Our ref: **CEB/GL/029196**

1st September 2021

Easton Estate – A47 Easton to North Tuddenham Road Improvement Scheme

Estate Plan with various issues marked for explanation of the text
Extract to show screening fence near Hall Farm underpass
Extract to show screening fence and extended embankment near Hall farm complex
Photos and DMRB standards to demonstrate the need for a 5m high underpass
Summary noise report

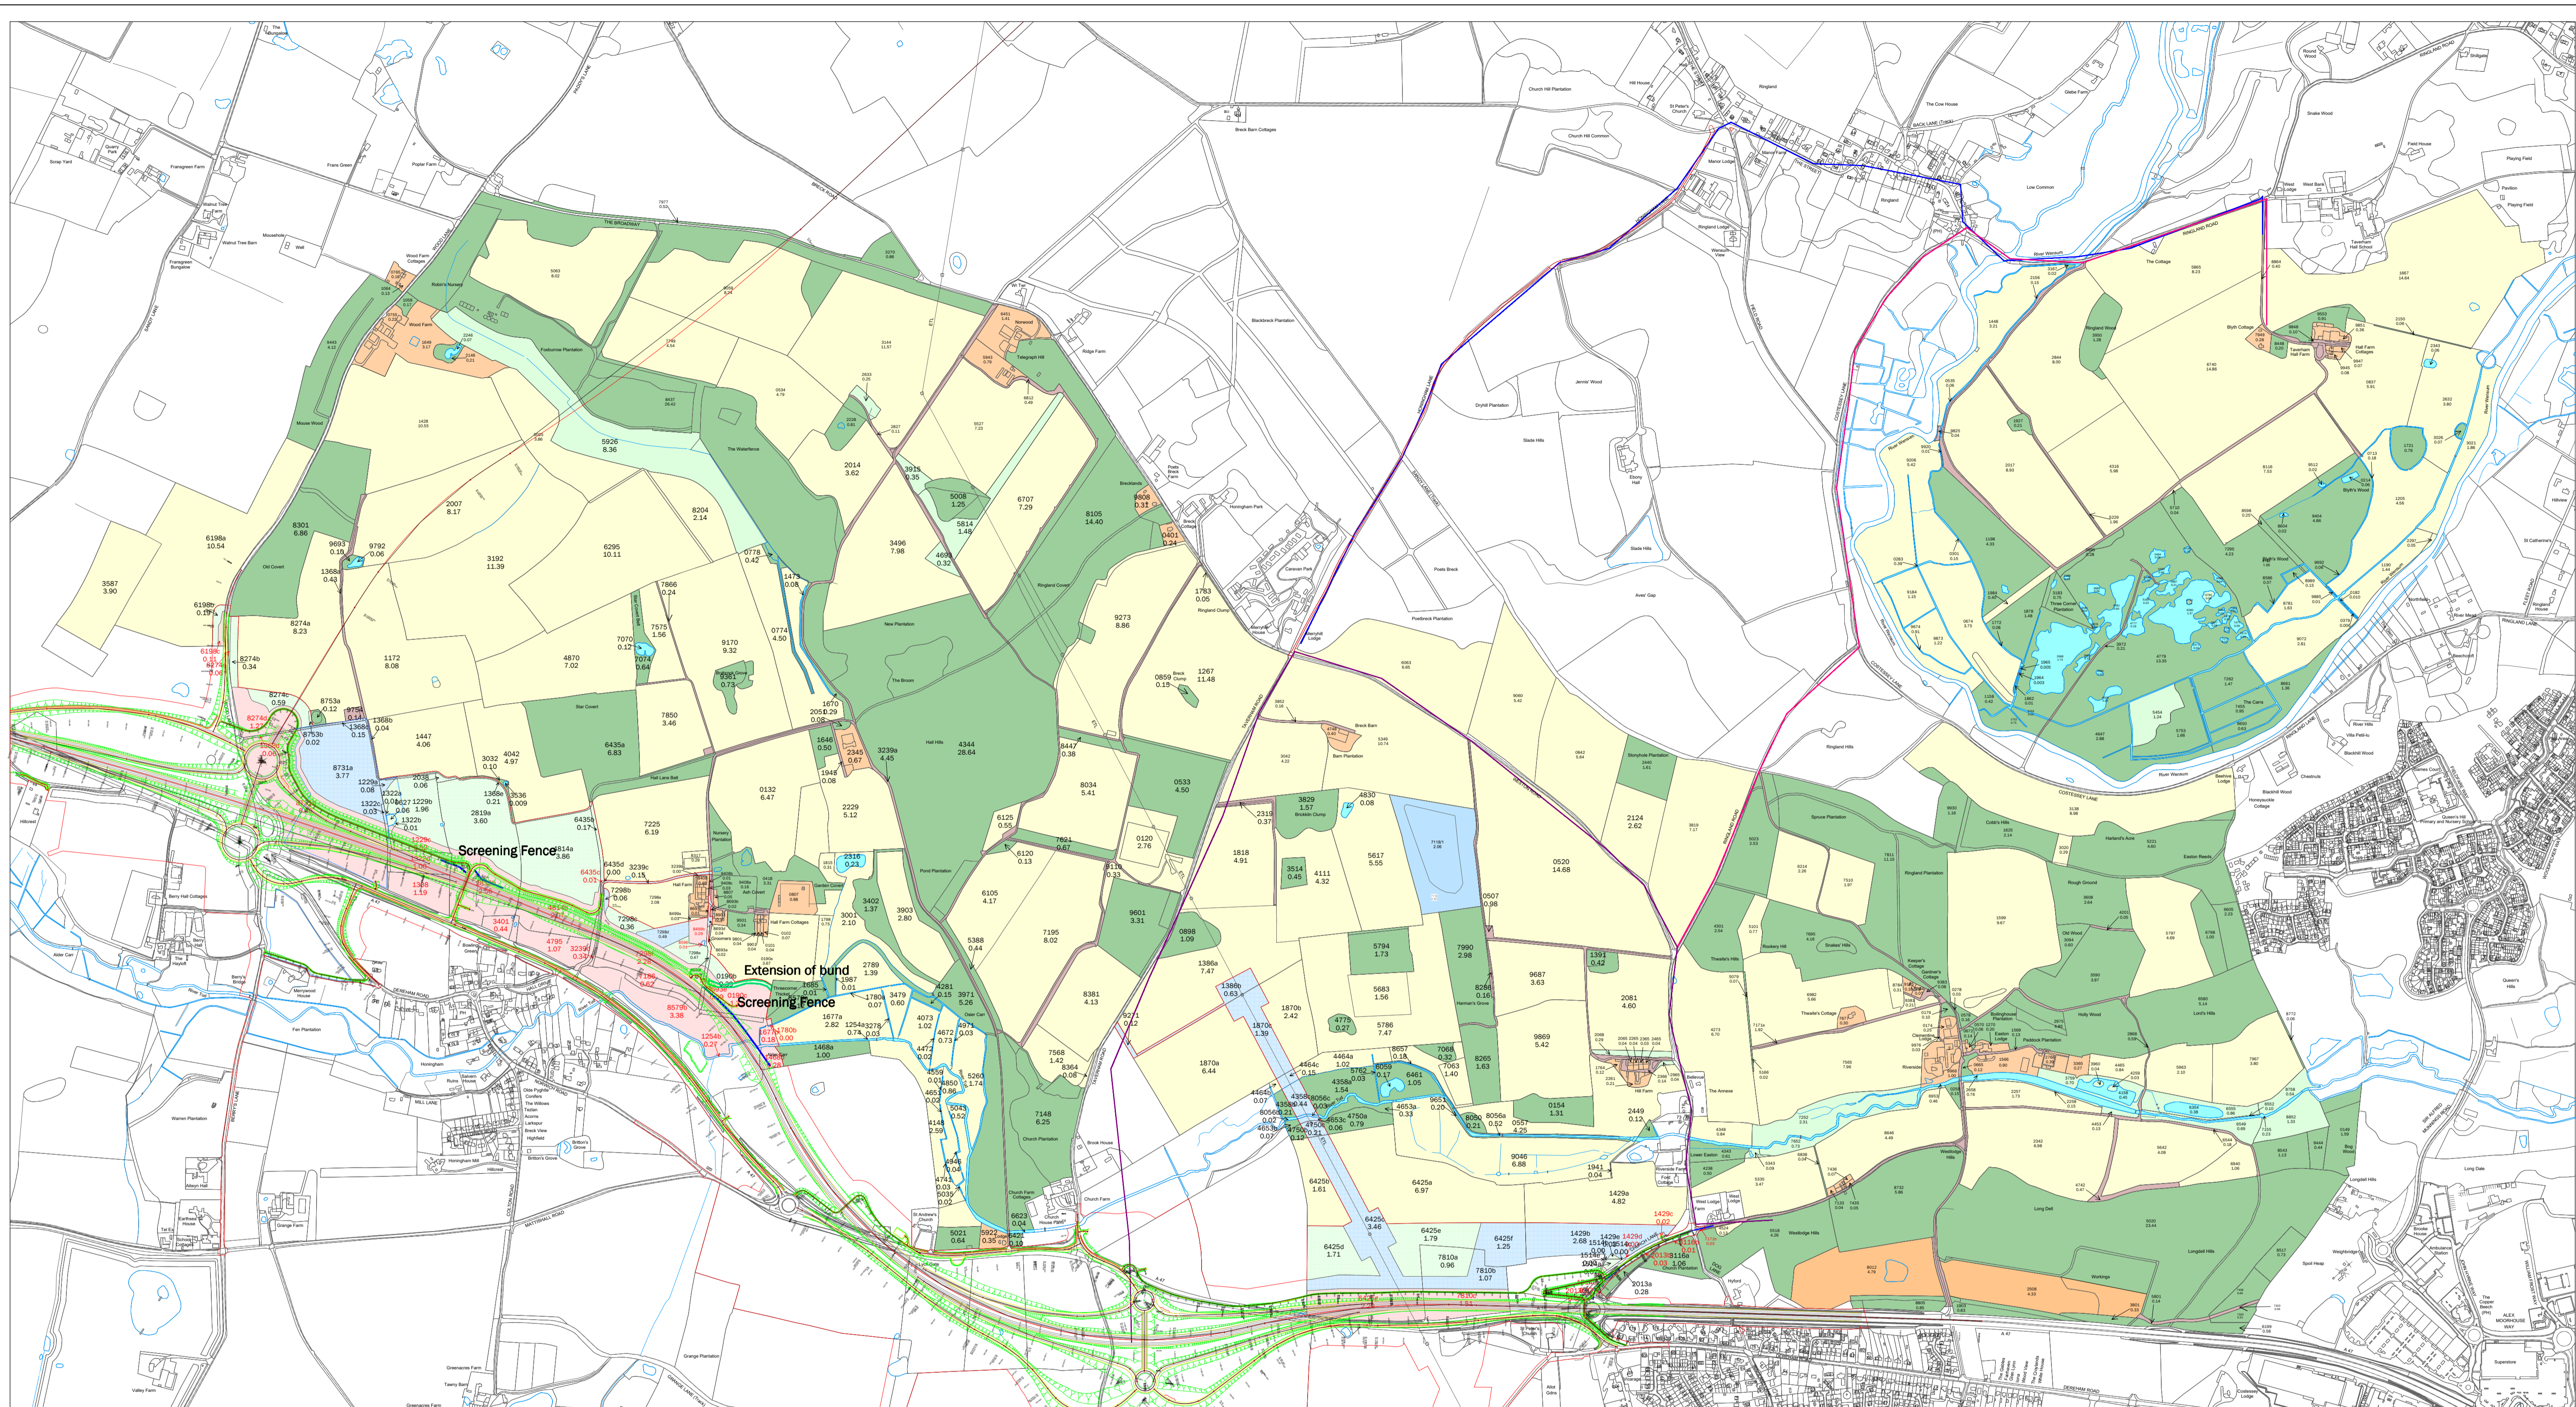
On the plan attached in the appendices, the current route is shown with a purple line progressing northwards to Ringland village along the blue route. The alternative turns east along the purple line and then north on the pink line.

The turn east into Weston Road leads to a very narrow lane, with a particularly difficult junction to turn north into Ringland Road and pass over Ringland Hills which is too narrow for large agricultural vehicles.

Access to the premises at Easton Lodge itself is along Church Lane, immediately accessible from the Easton roundabout which is to be closed. This is shown with a short blue line which takes less than 1 minute to travel safely along.

The alternative is a full 3.25 kms further and far narrower and more tortuous, shown by the long purple route north along Taverham Road, east into Weston Road and then south. This is much longer and much less safe for any vehicle type.

MAP FILENAME : Plan 1

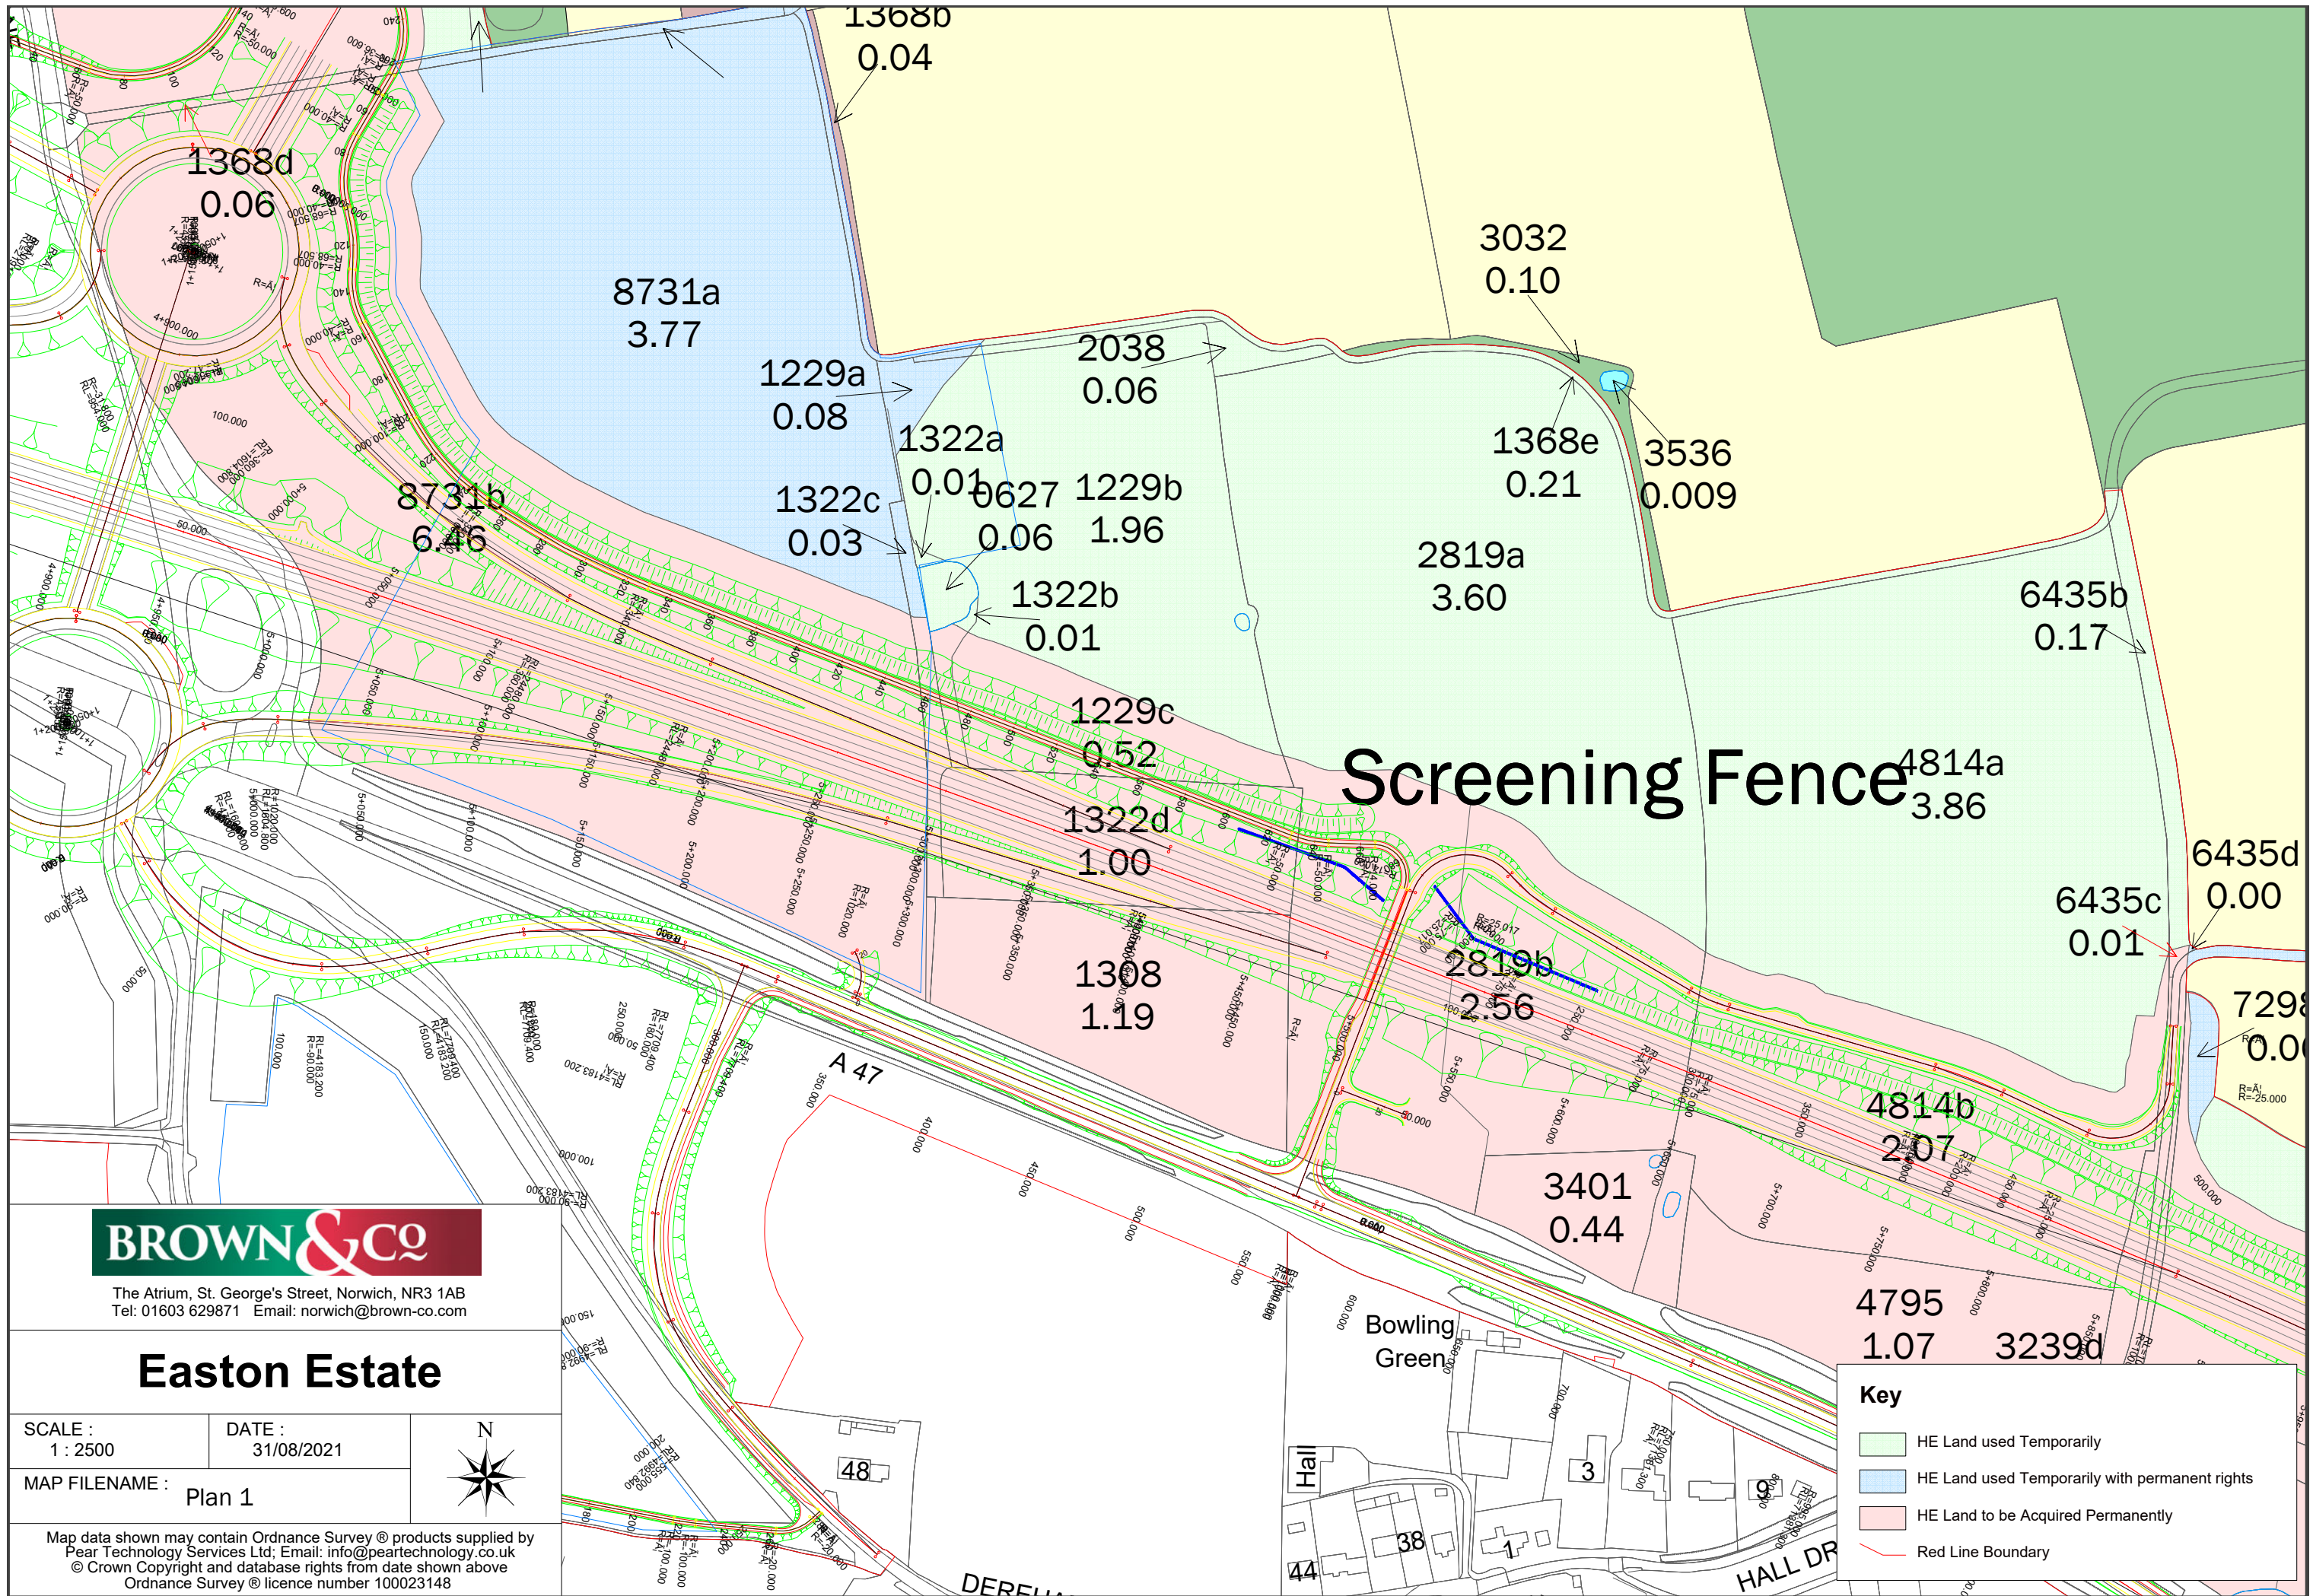
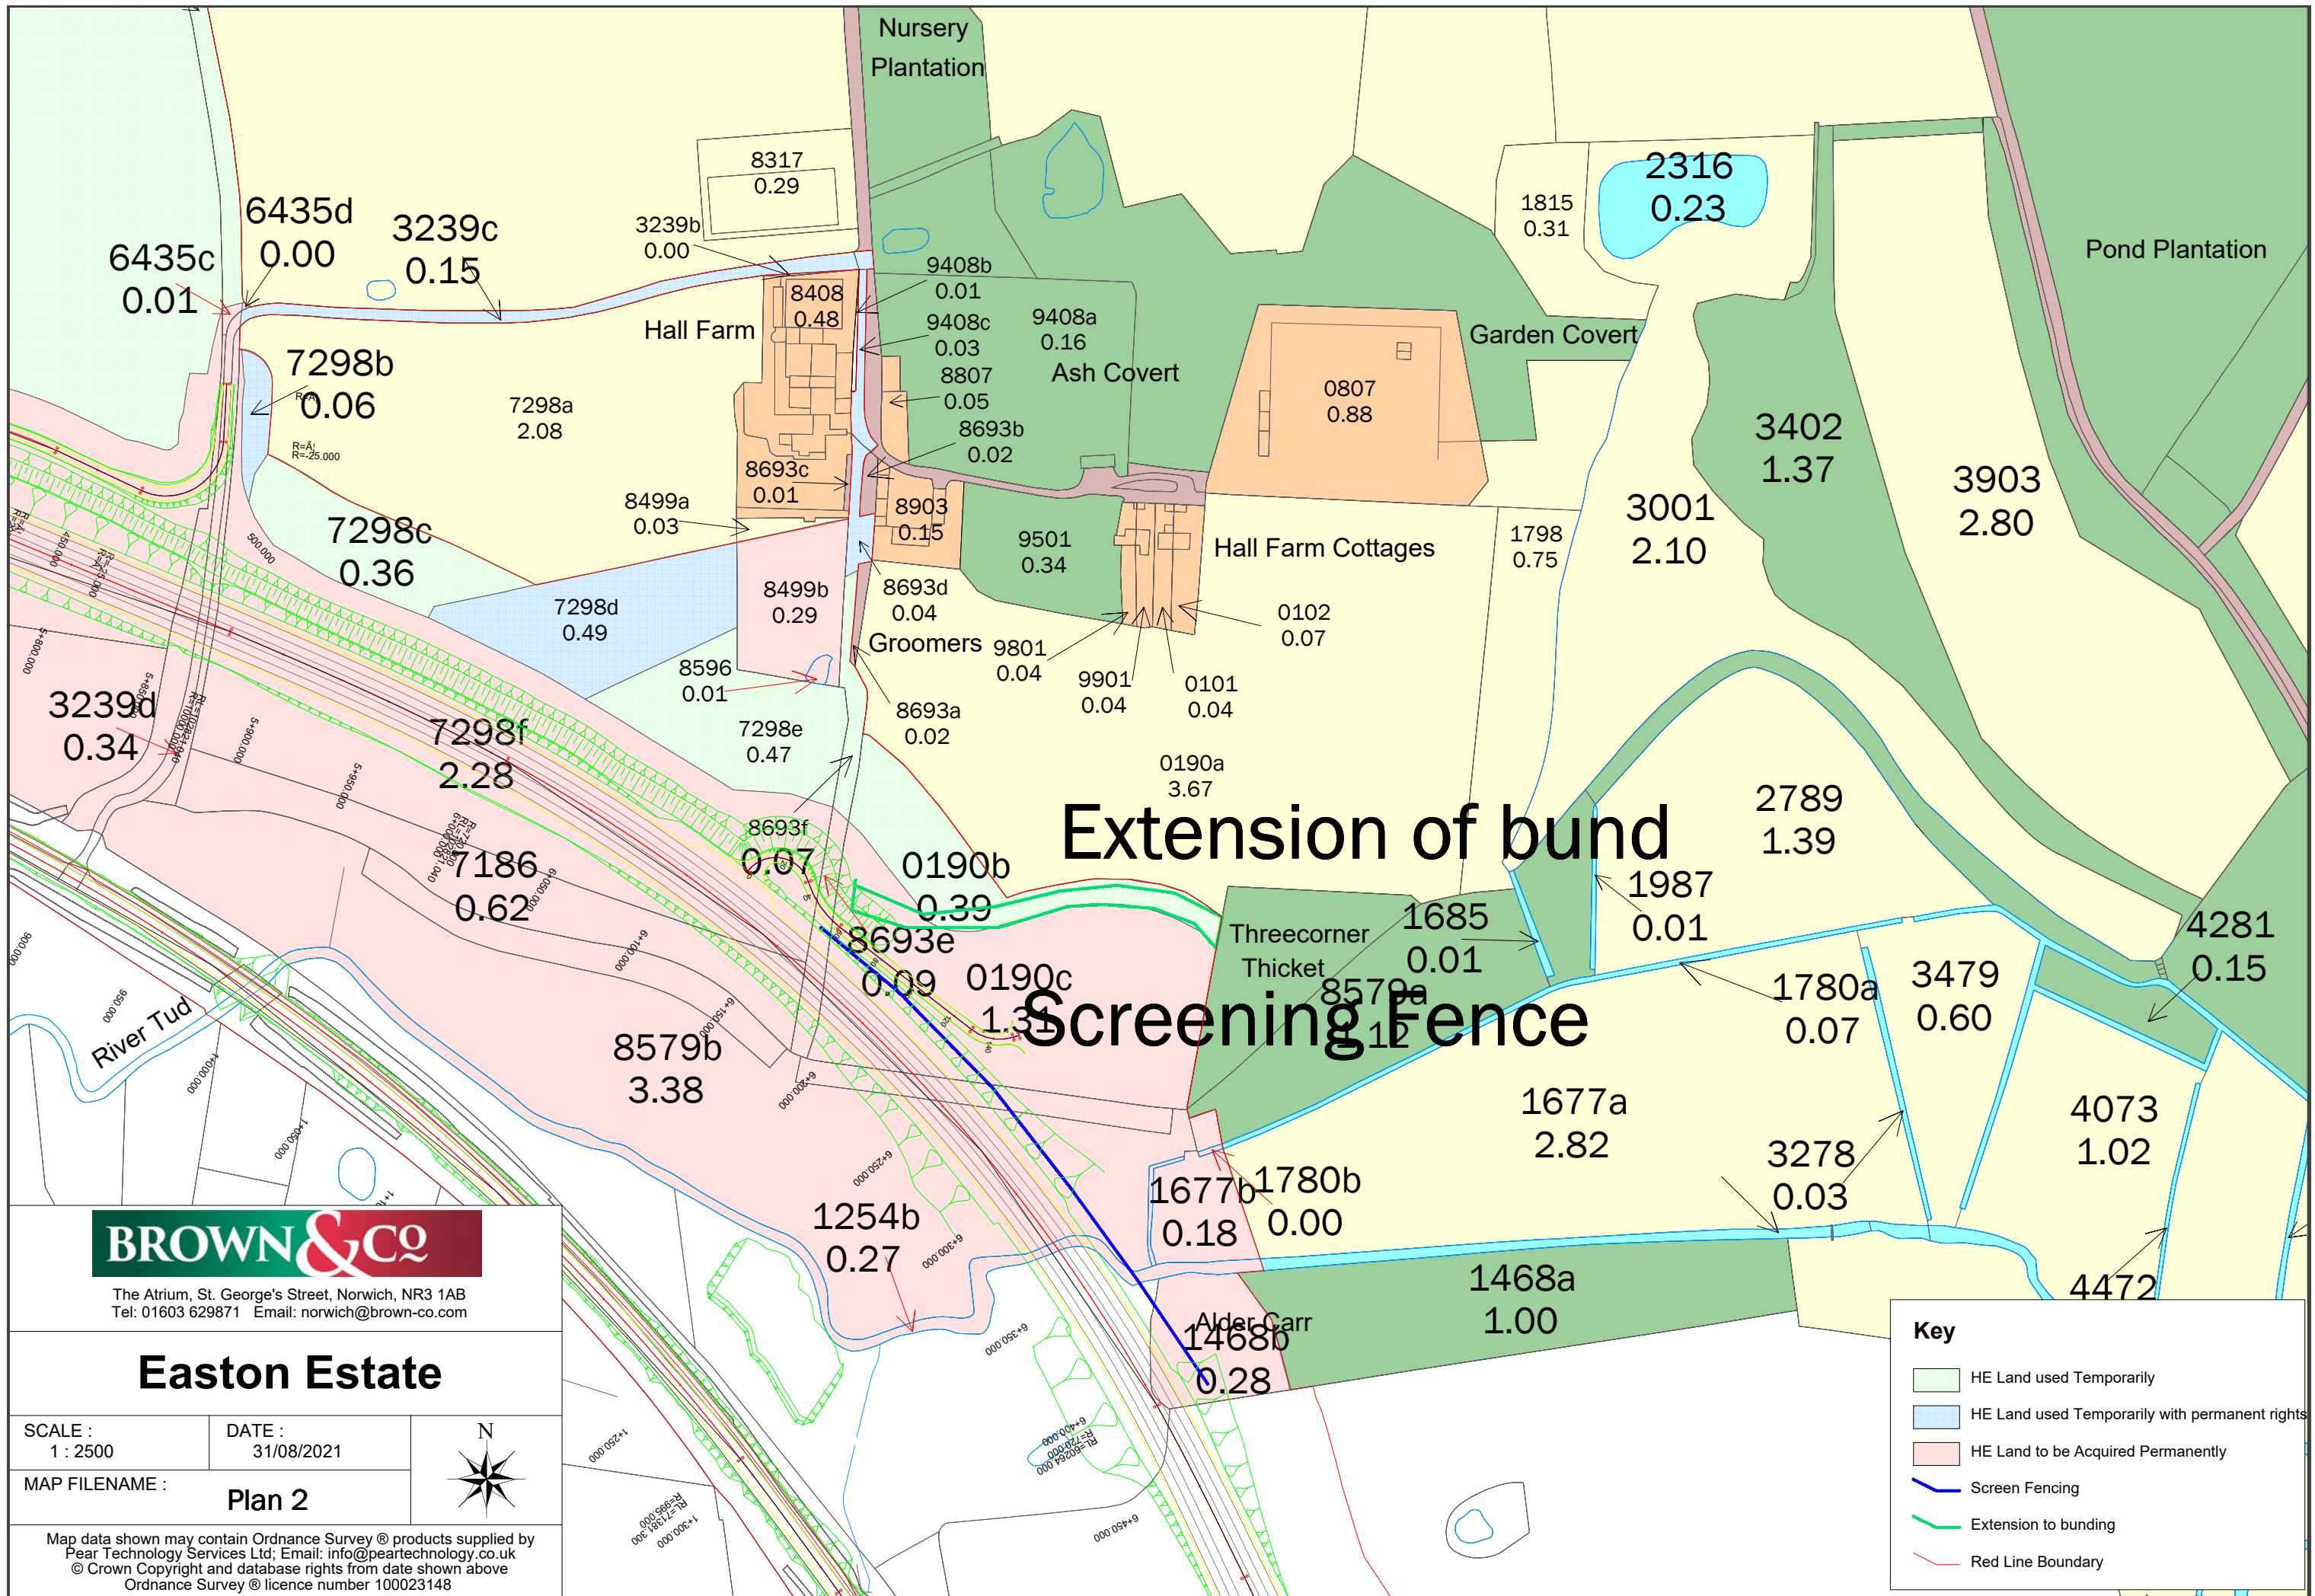
There are two areas we are aware of where screening fencing could add significantly to mitigation measures, but until now the Applicant has declined to discuss them. These are shown approximately in the Appendices.

Area 1:

Hall Farm underpass is situated across a low area in the landscape, so the carriageway will be elevated leaving the estate and the carriageway highly visible. We understand the Applicant doesn't intend to overlap embankments around the access to screen this elevated section, possibly for wildlife reasons.

We have been advised it is not possible to construct a fence on the edge of the carriageway due to wind loading, but a higher-than-normal solid edged safety barrier or a screen fence situated on the adjacent embankment or the edge of the carriageway and carefully designed is likely to mitigate impact from what is a relatively short section of road.
